## **Grindleton Parish Council response to planning application for the Duke of York Grindleton**

In the application there is a request for change of use on the public house known as the Duke of York.

Drawing Title
 EXISTING ELEVATIONS

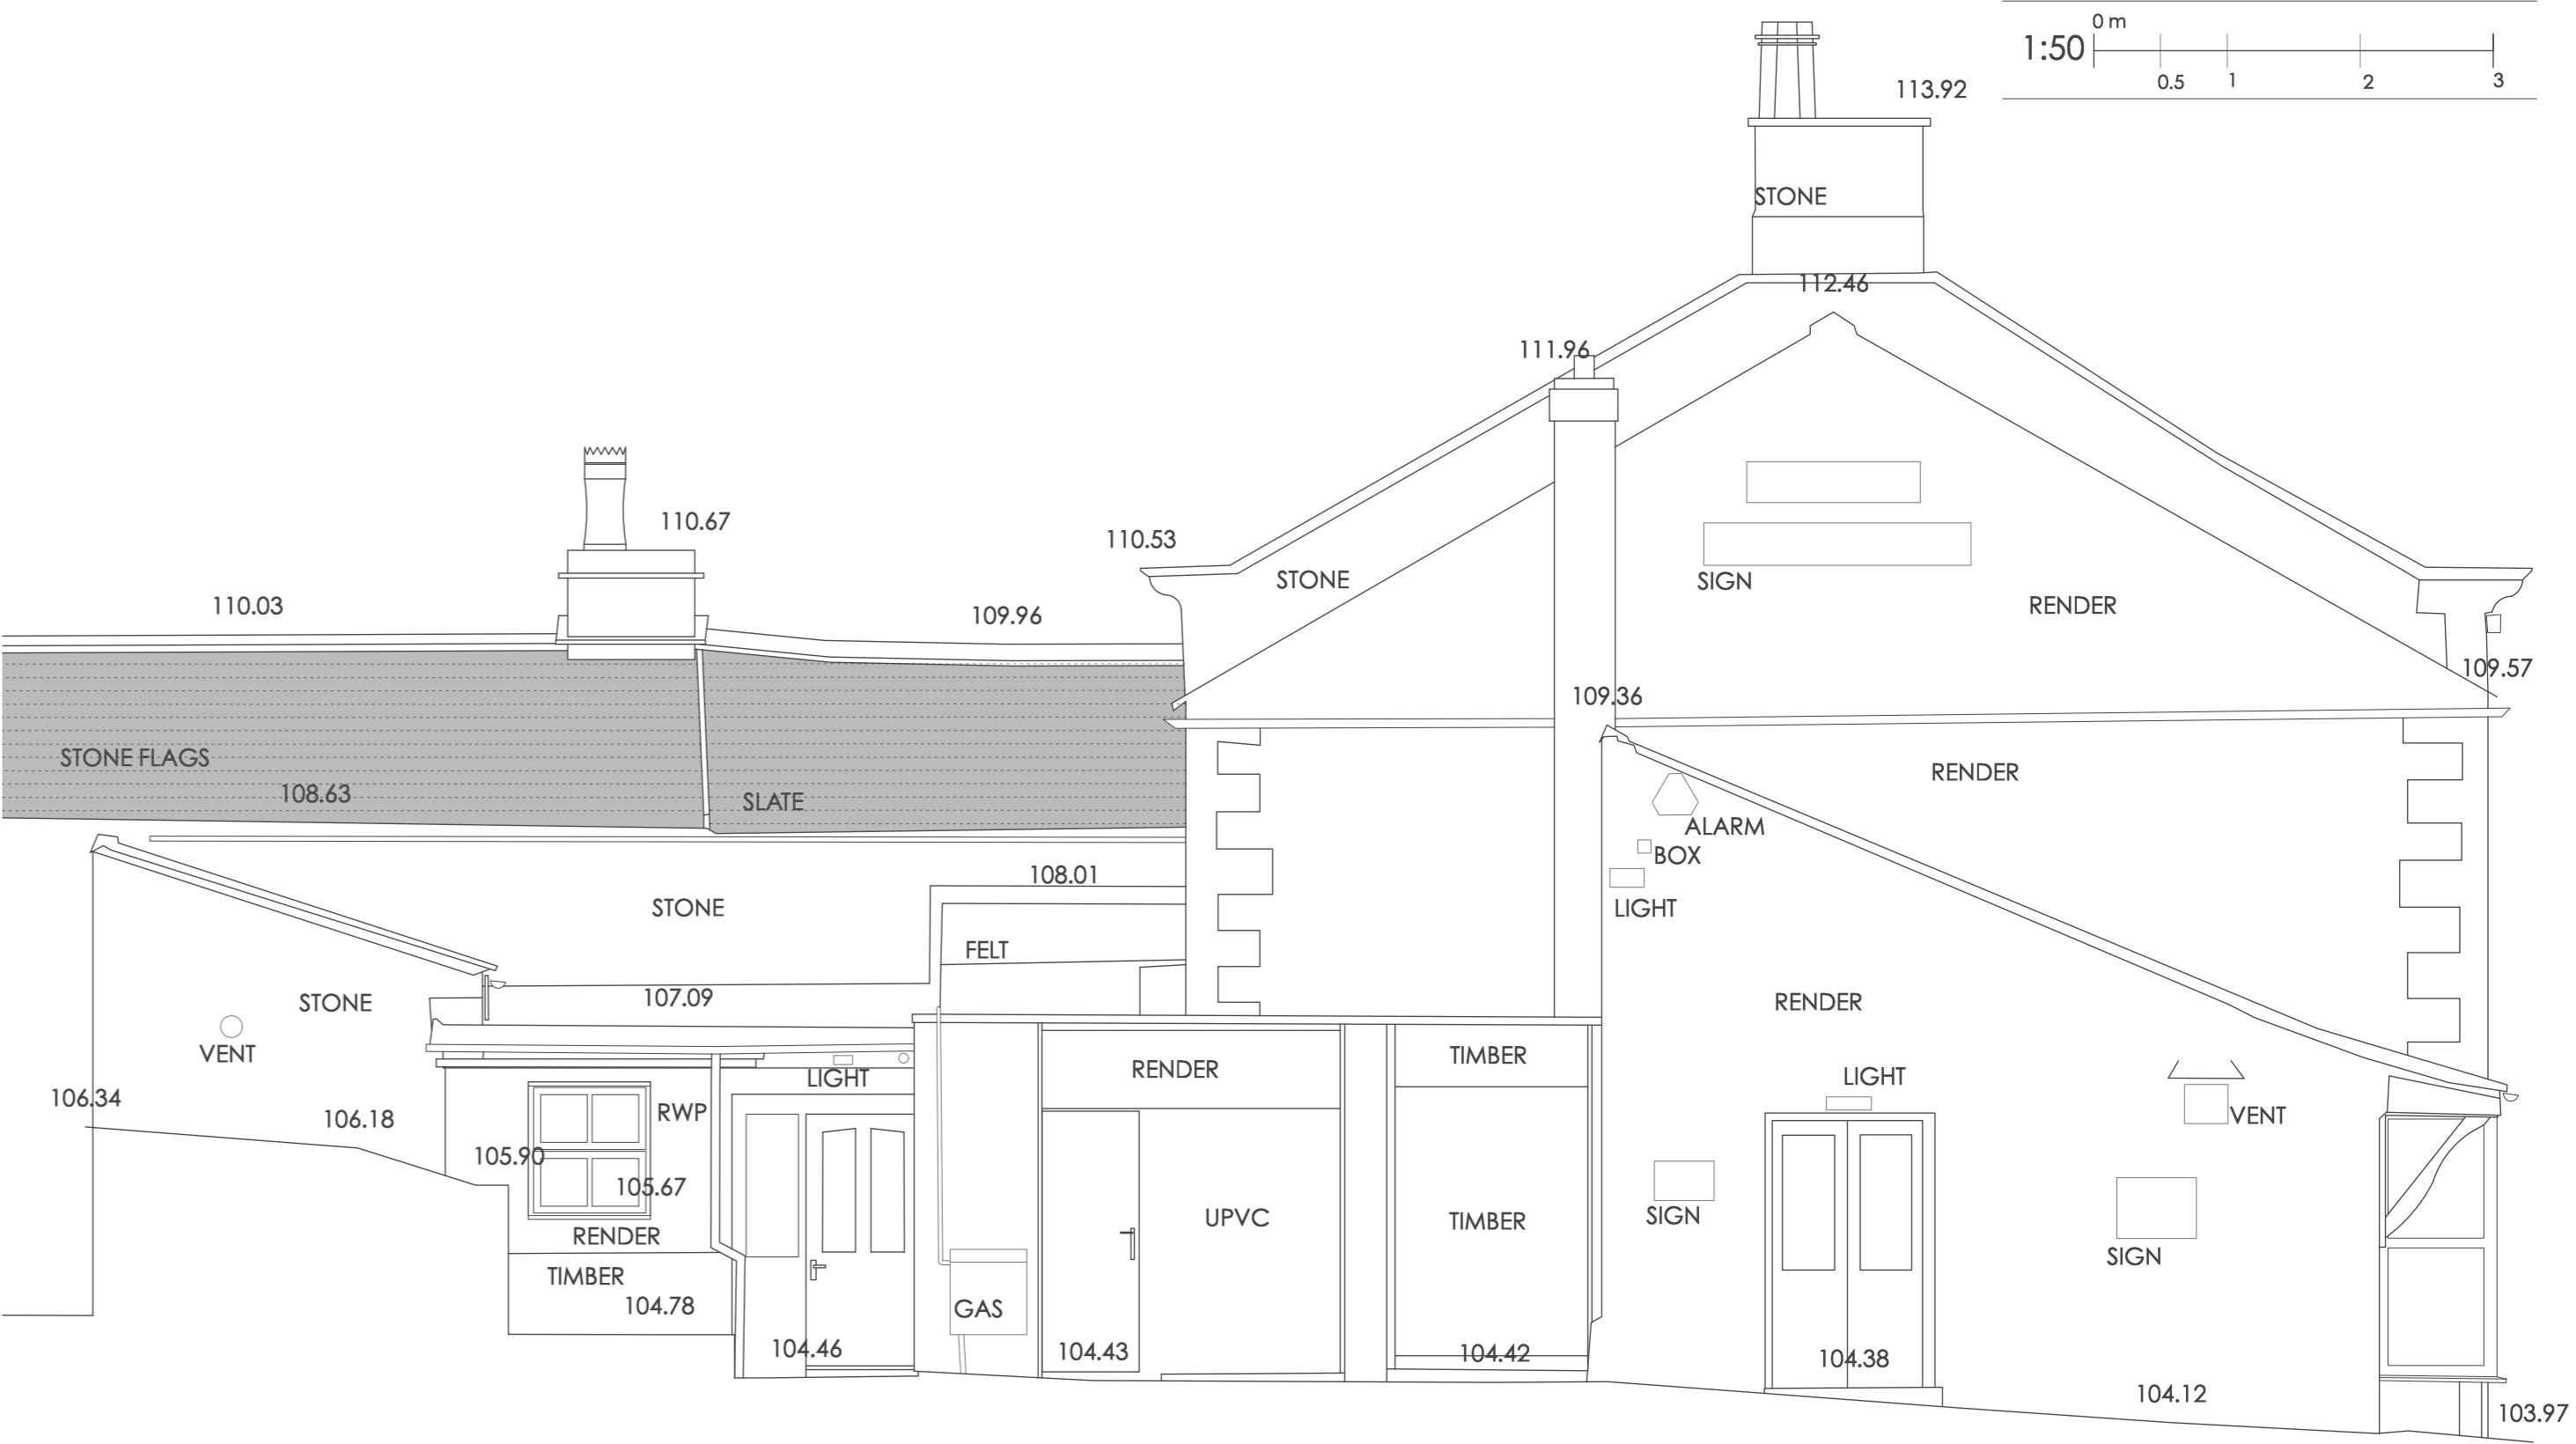
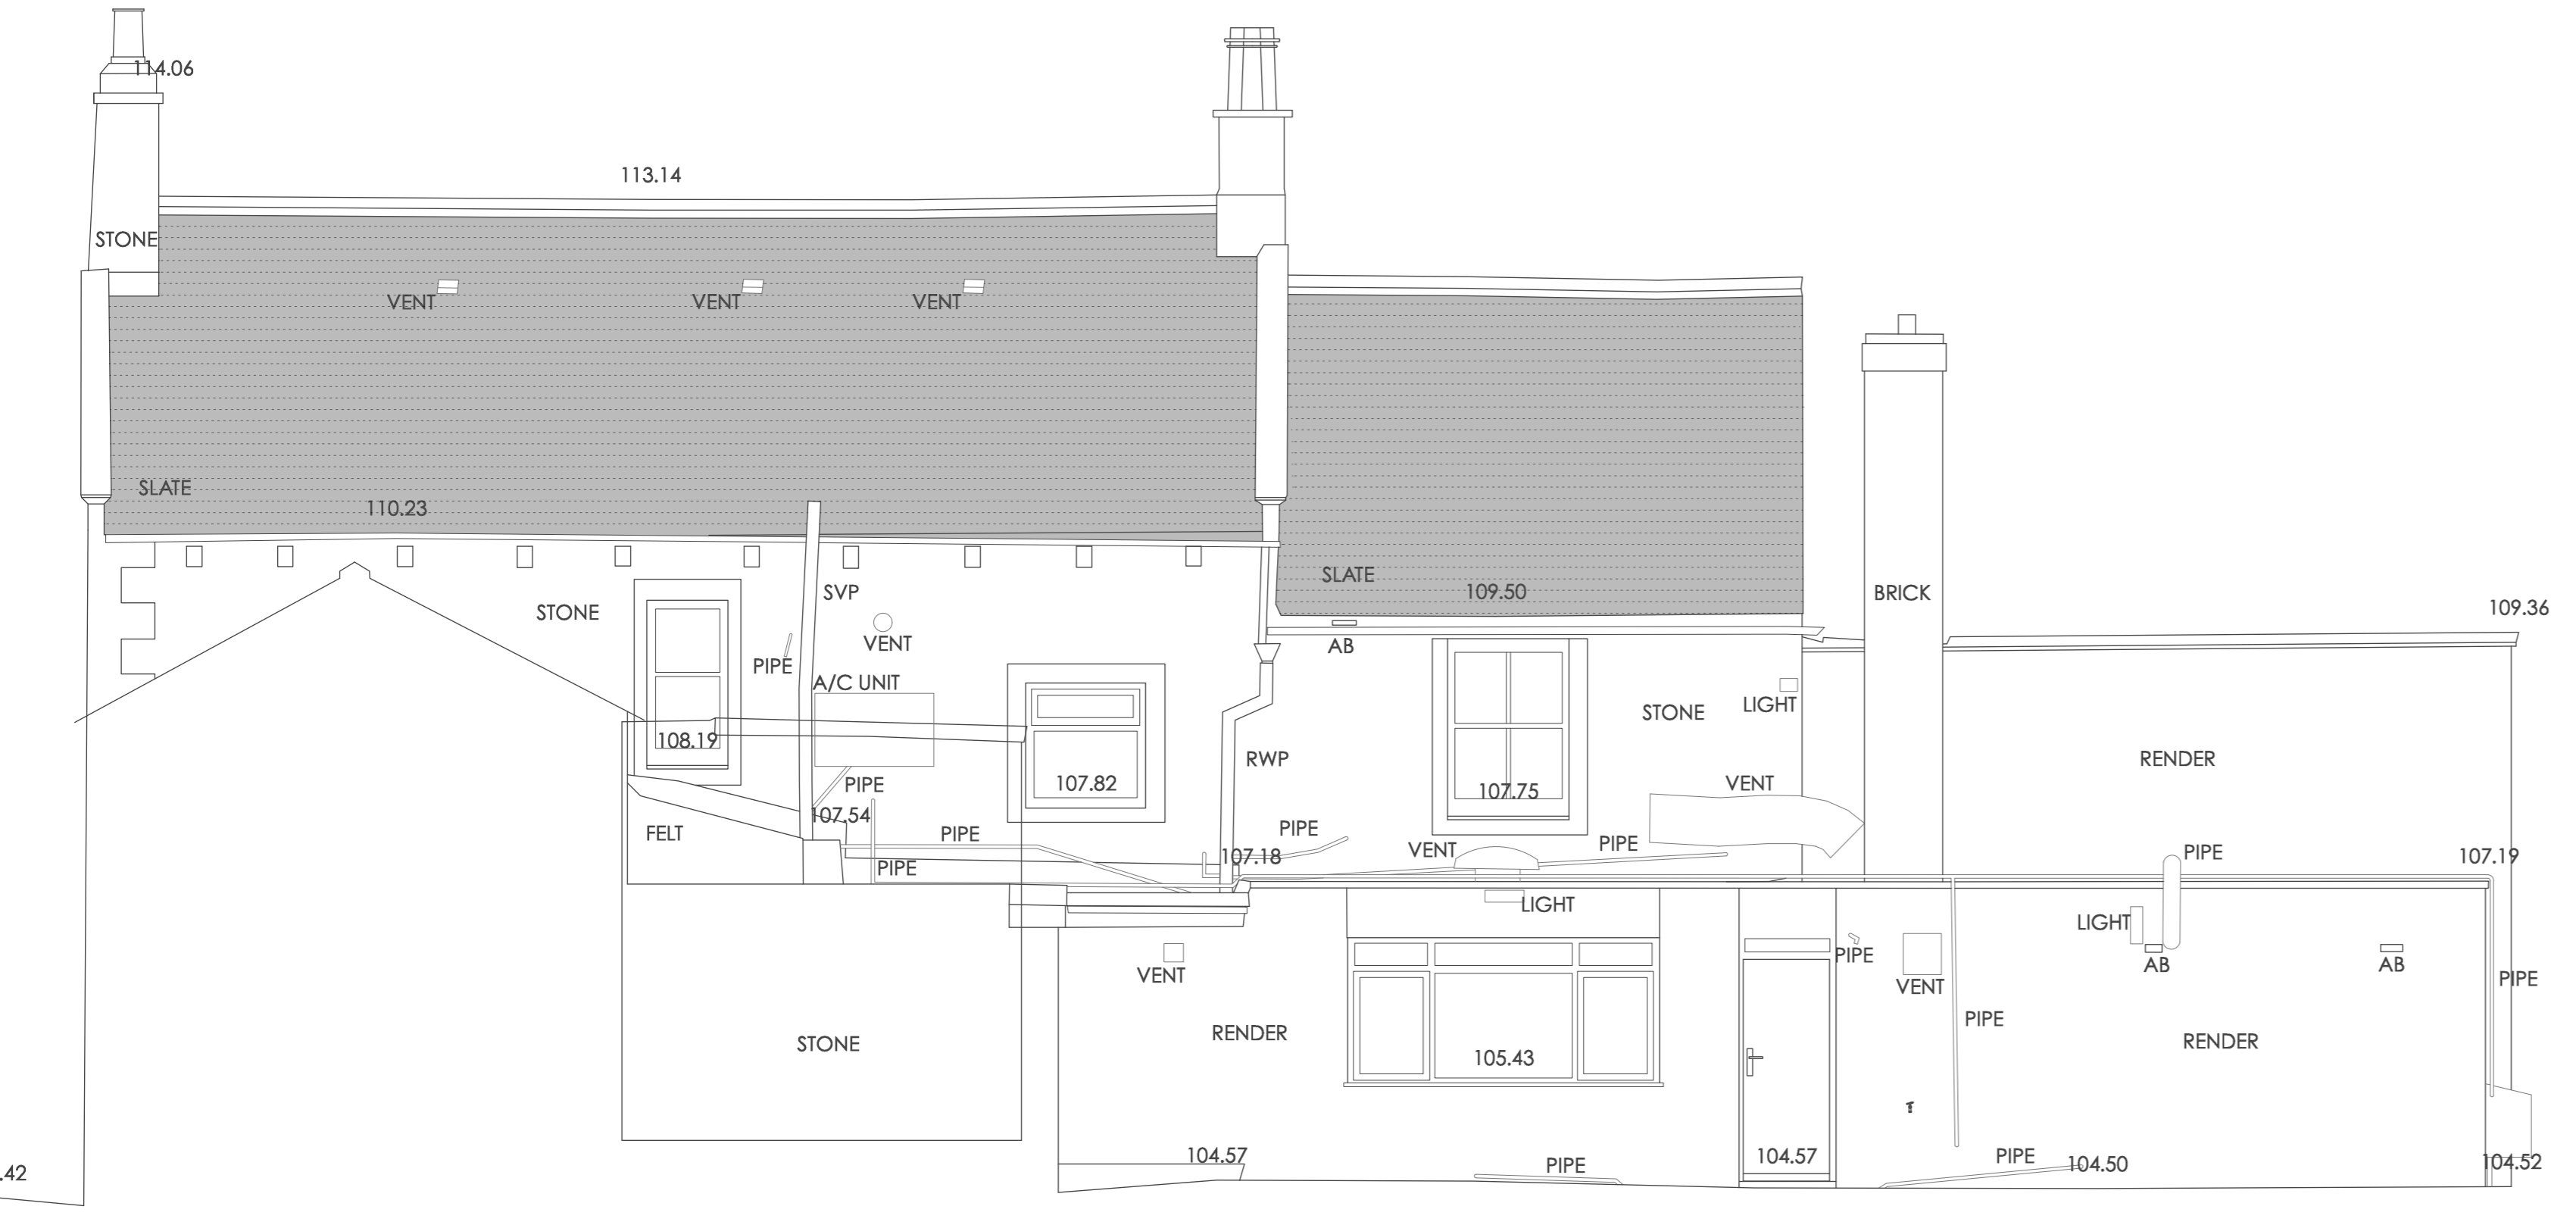
The Duke of York pub as you will be aware is a grade 2 listed building in a conservation area. Whilst we appreciate that the applicant wants to remove the 1970s glass extension from the side of the building, and whilst this will aesthetically improve the look of the building, we realise that this area is the pub's dining room, and once demolished, the building would never return to being a gastro pub.

Previous owners of the building tried to establish decking outside the front and this was refused by the planners. We would hope the RVBC look at the building in the same light today and protect the look of the front facade.

Drawing Title
 PROPOSED HOLIDAY LETS:
 ELEVATIONS

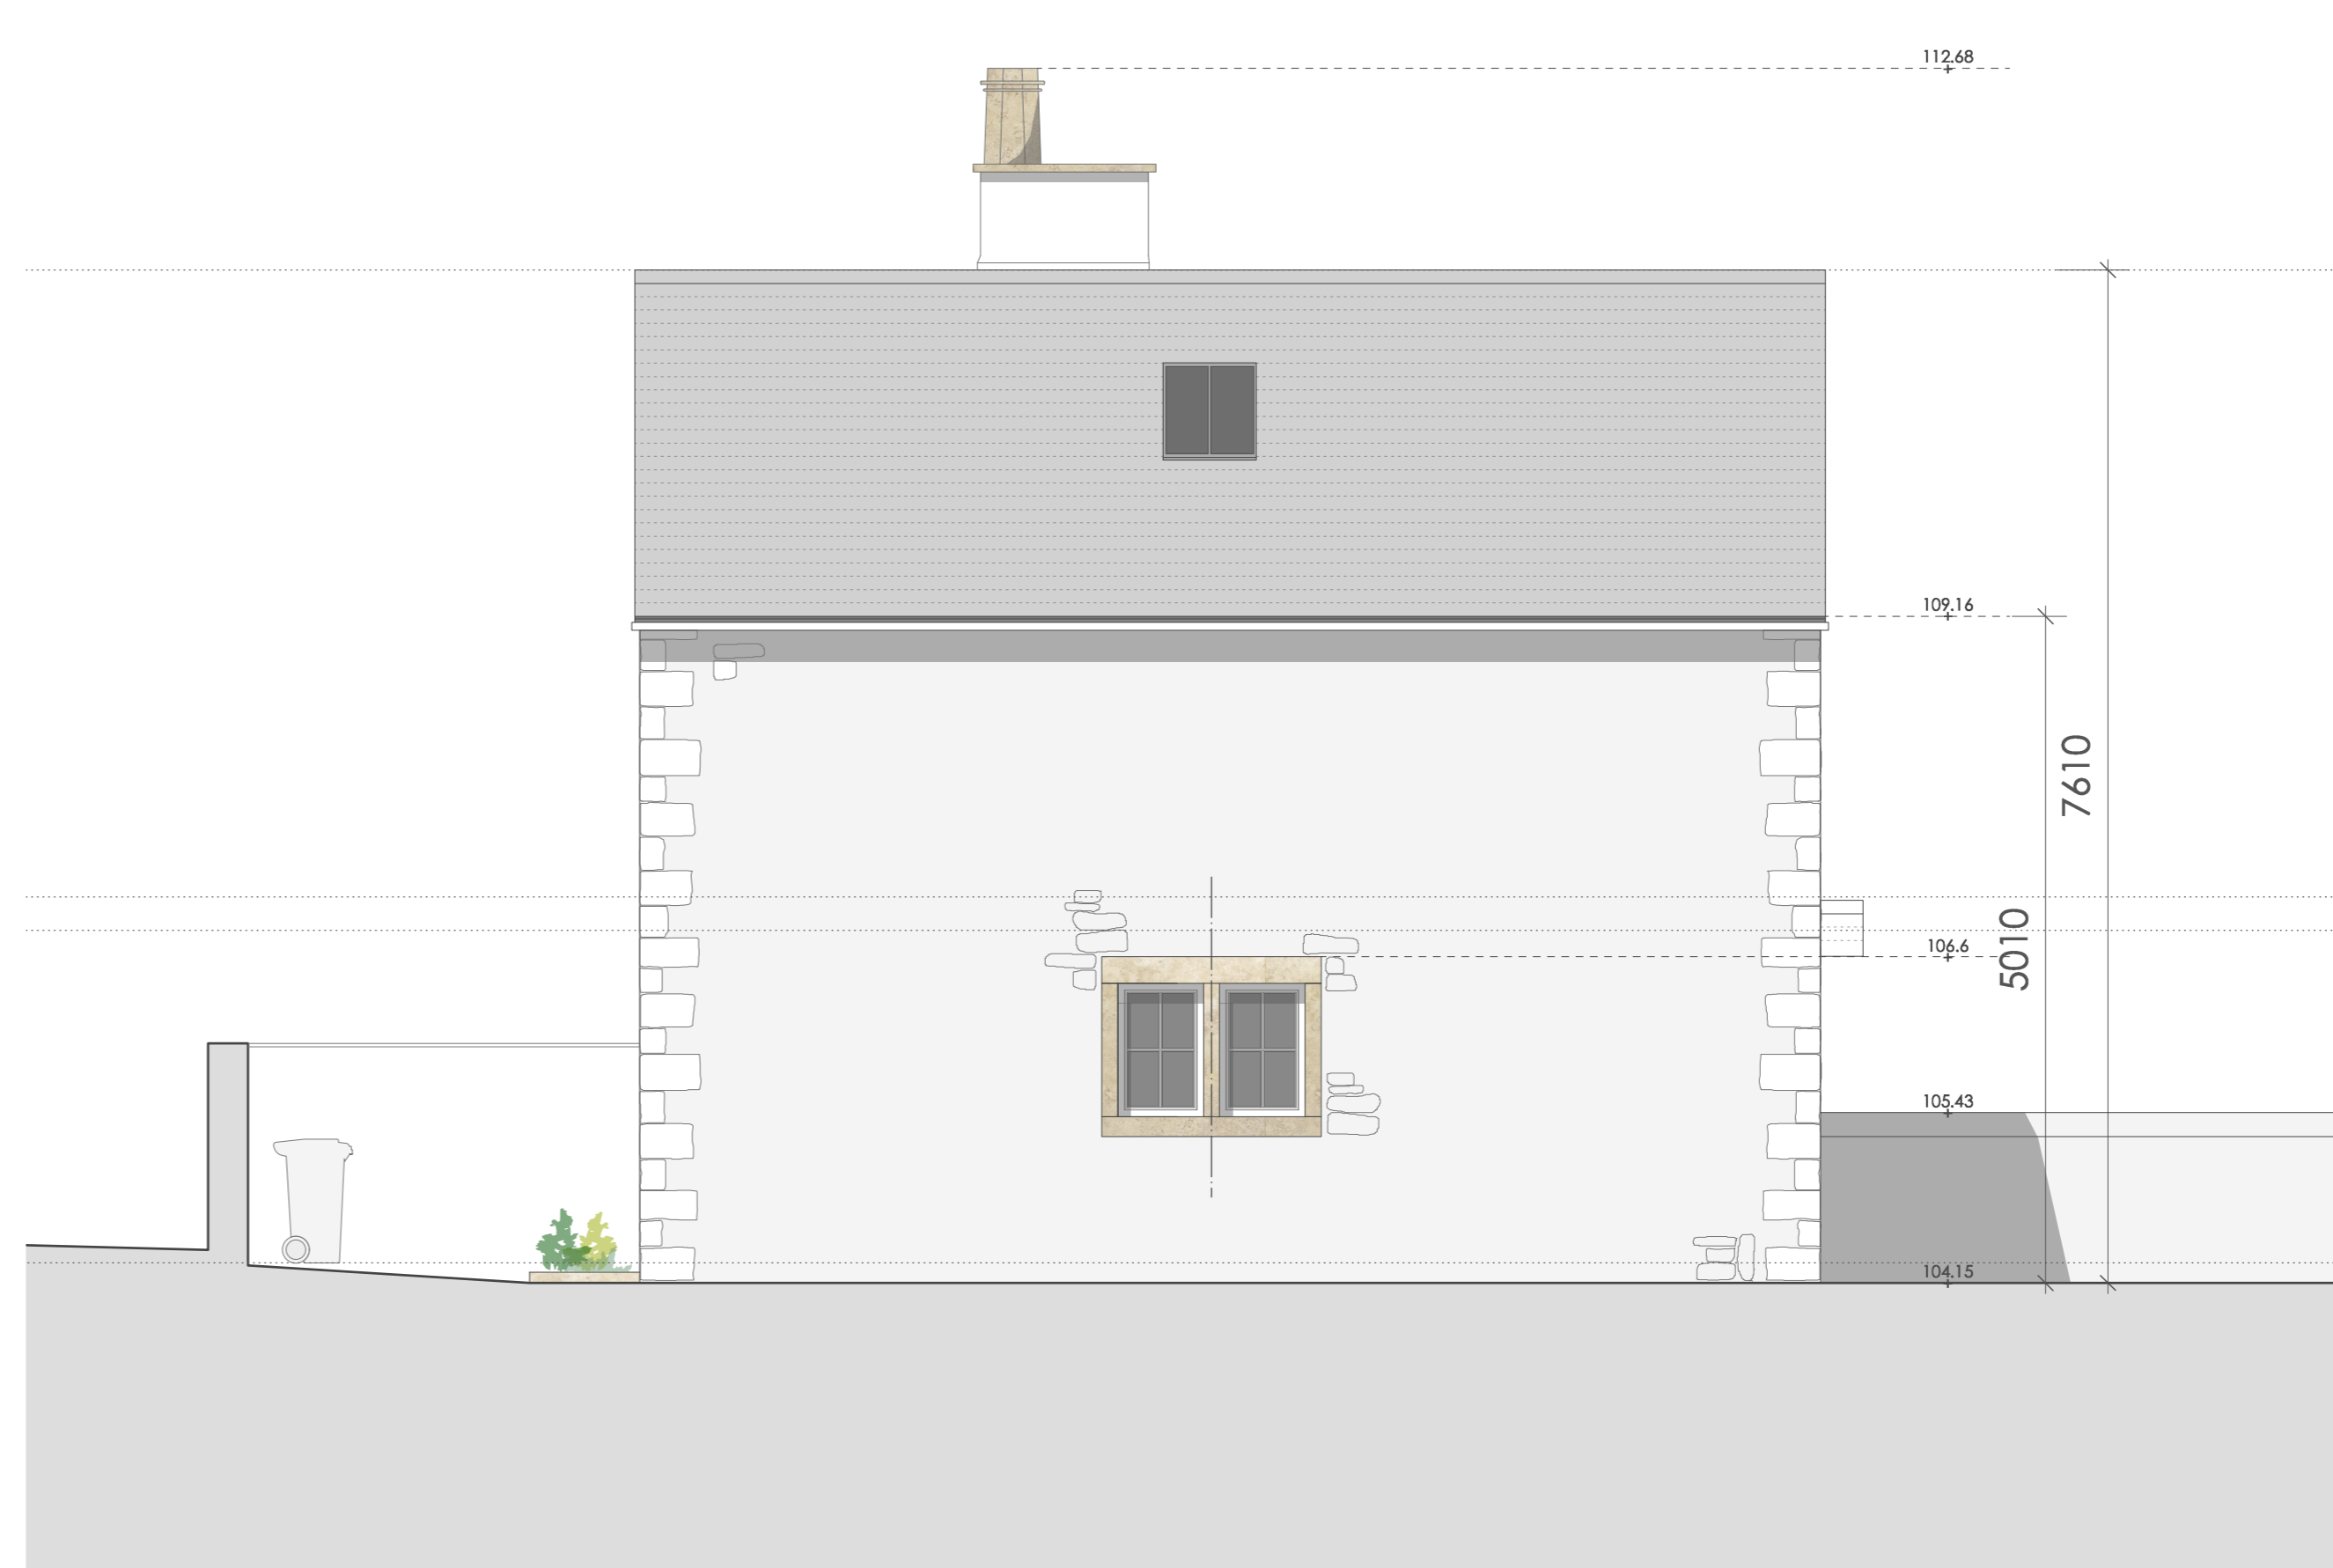
As this is the entrance to the village, this construction has the potential to alter the 'character' of the village. It is felt that the materials used to construct the holiday cottages would need to be sympathetic / in keeping with its surroundings, so as not to adversely impact the area.

The construction of the holiday lets is within a conservation area and has the possibility of impacting visually on the grade 2 listed building by being built with new materials and built in a modern way. The balance of new developments on the same site of existing historic buildings is a tricky balance. It is very

easy for new builds to take away the look of existing buildings. We question whether this meets your key statement EN2?
